Our Ref: 2023/105859
File No: R/2023/5
Your Ref: SSD 47662959

Royal Prince Alfred Hospital Redevelopment – SSD 47662959 – Advice on EIS

Thank you for your correspondence dated 1 February 2023 inviting the City of Sydney Council (the City) to comment on the proposed redevelopment of Royal Prince Alfred Hospital (RPA).

**Existing Tree Canopy
Coverage Plan**

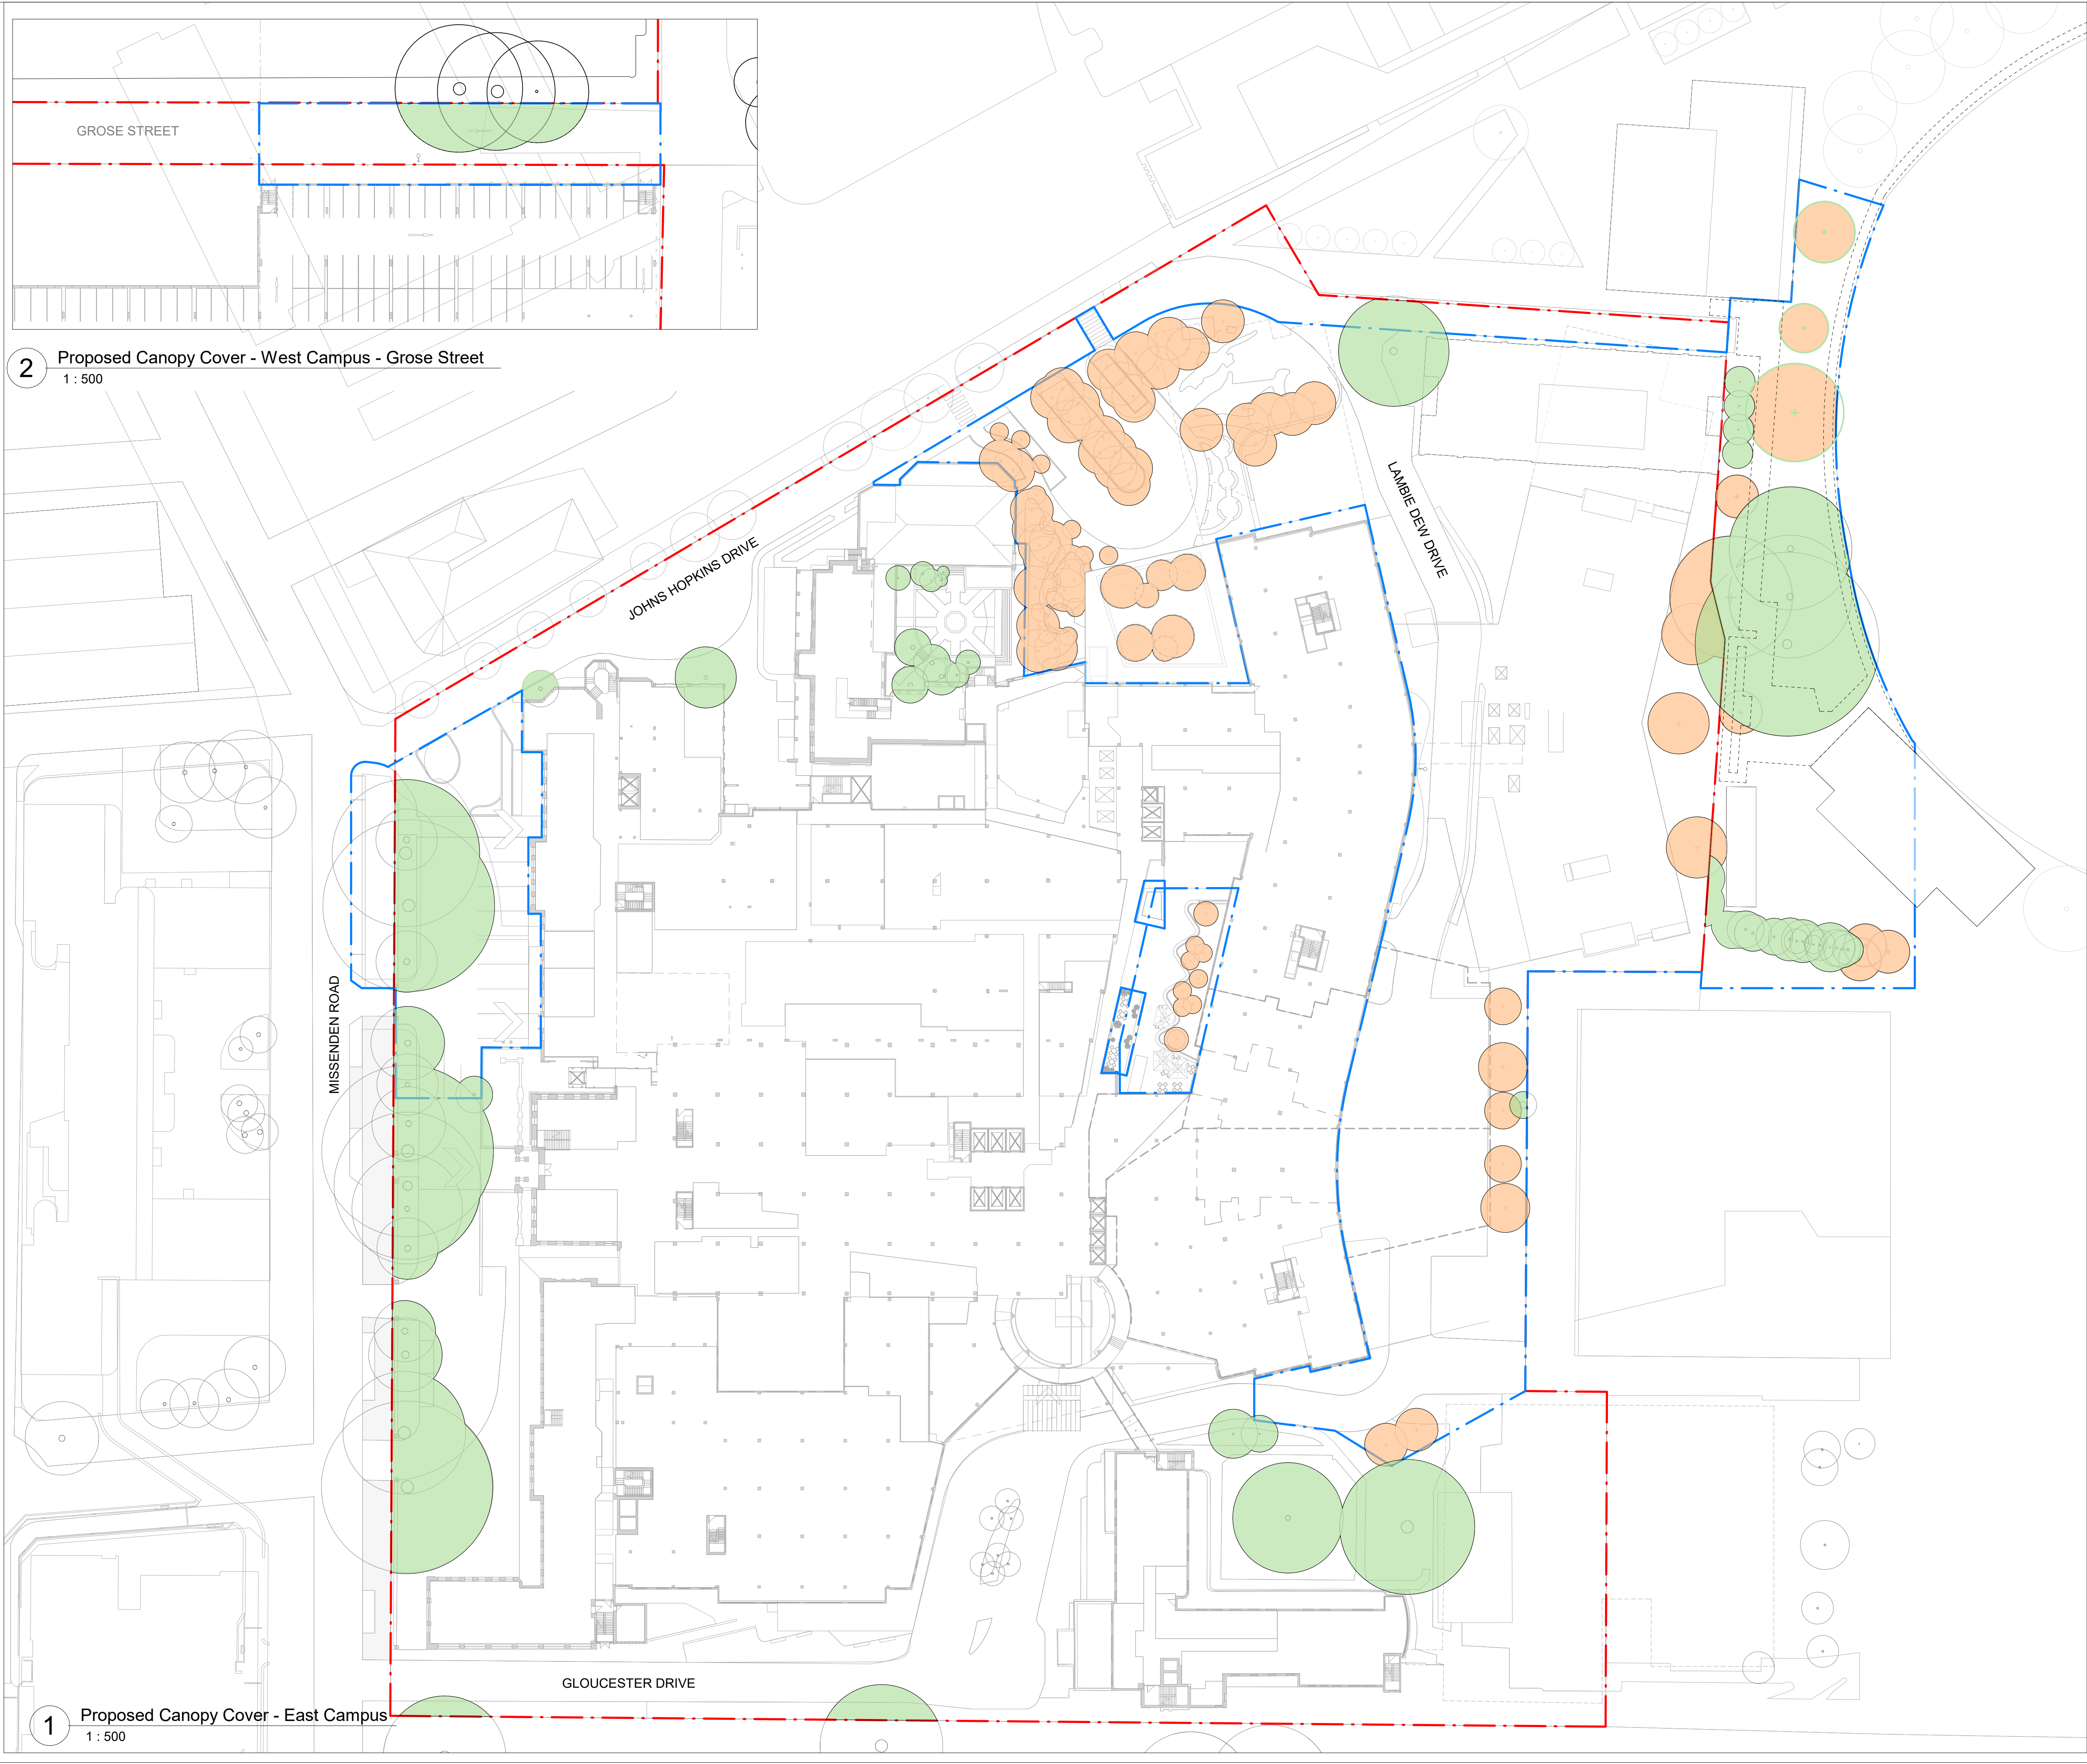
The landscape plan indicates that the total existing canopy cover for the site is 17.2%. The total proposed canopy for the site is 13.4%. Due to the proposed reduction of the existing canopy, this falls below the minimum. Additionally, the submitted plant palettes for each area do not include tree and palm pot sizes, noting palms have a much smaller

canopy than a tree. It is questioned how canopy coverage (dwg L-DA-39) has been calculated.

- *It is recommended that plant schedules include all tree and palm pot sizes at installation and that further information to confirm how tree canopy coverage has been calculated be submitted.*
